A428 Black Cat to Caxton Gibbet Road Improvement Scheme – Deadline 8

Appendix 1 – Deadline 8 Submission

THE CHURCH COMMISSIONERS FOR ENGLAND
DEADLINE 8 SUBMISSION

2.2 Q3.6.2.1: Comments on Annex R Borrow Pits Management Plan (**Plan**) in the First Iteration EMP [REP6-008]. CCE owns the land immediately east of the A1198 (Ermine Street) and north of the existing A428 (Cambridge Road) which is to be used for a borrow pit as part of the A428 improvement scheme and is referred to as "Site 3" for the purposes of the Plan. CCE welcomes the further details on key stakeholder engagement in relation to the borrow pits and on baseline conditions, mitigation and restoration set out in the Plan. CCE wishes to make the following comments:

Figure 4-1: Site 3 Location Plan

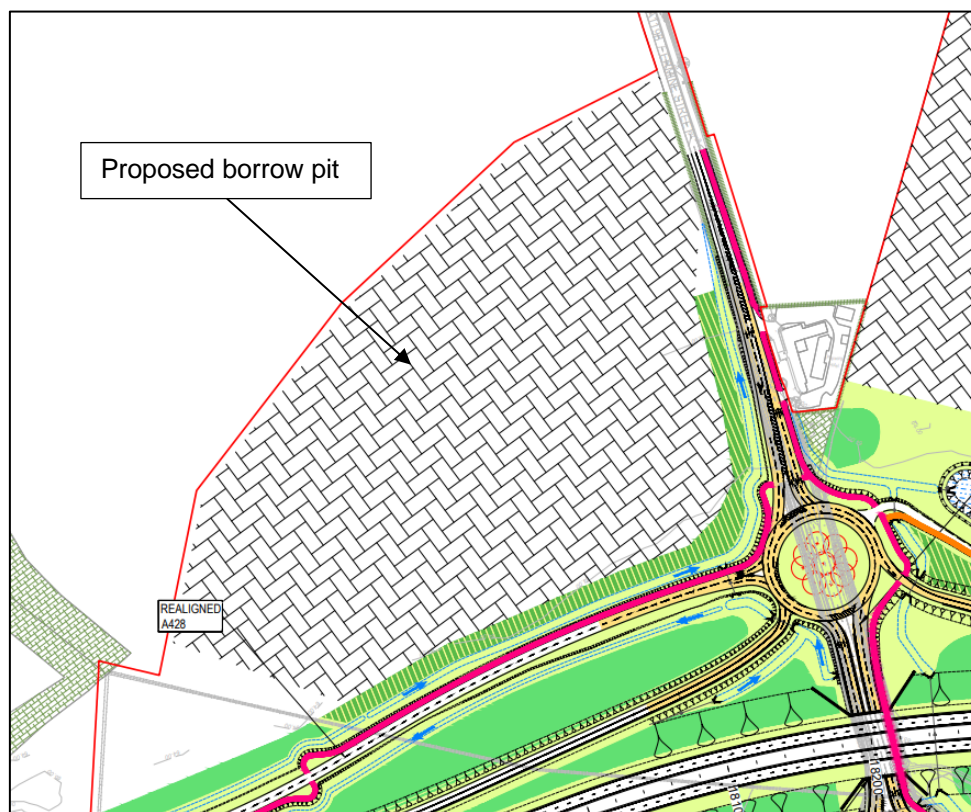
- 2.2.3 The Plan states at R-15 that access for a detailed soil survey of Site 3 was not granted. NH have not made any requests for access to undertake soil surveys to CCE as the freehold owner or their consultants. CCE can and will grant consent for detailed soil surveys to be undertaken. This should be done to obtain a full record of the condition of the soils and detailed analysis of items such as organic matter, nutrient content, fertilizer levels and compaction. Such a record is necessary to ensure that the reinstatement of soil at the end of the scheme is to an equal quality as the soil prior to the scheme. CCE requests that the Plan requires that the results of any such survey are shared with landowners prior to the works commencing.

- 2.2.5 The Plan refers at R-34 to archaeological sites identified within the borrow pit at Site 3 being subject to archaeological excavation in advance of the construction of the borrow pit. The Plan should specify that landowners will be notified as to when such excavation works will commence and provided with details of the outcome.

- 2.2.8 For clarity, the Plan should include red line plans showing the location and boundaries of the borrow pits as was included in the Borrow Pits Excavation and Restoration Report submitted at Deadline 3 [TR010044/EXAM/9.24].
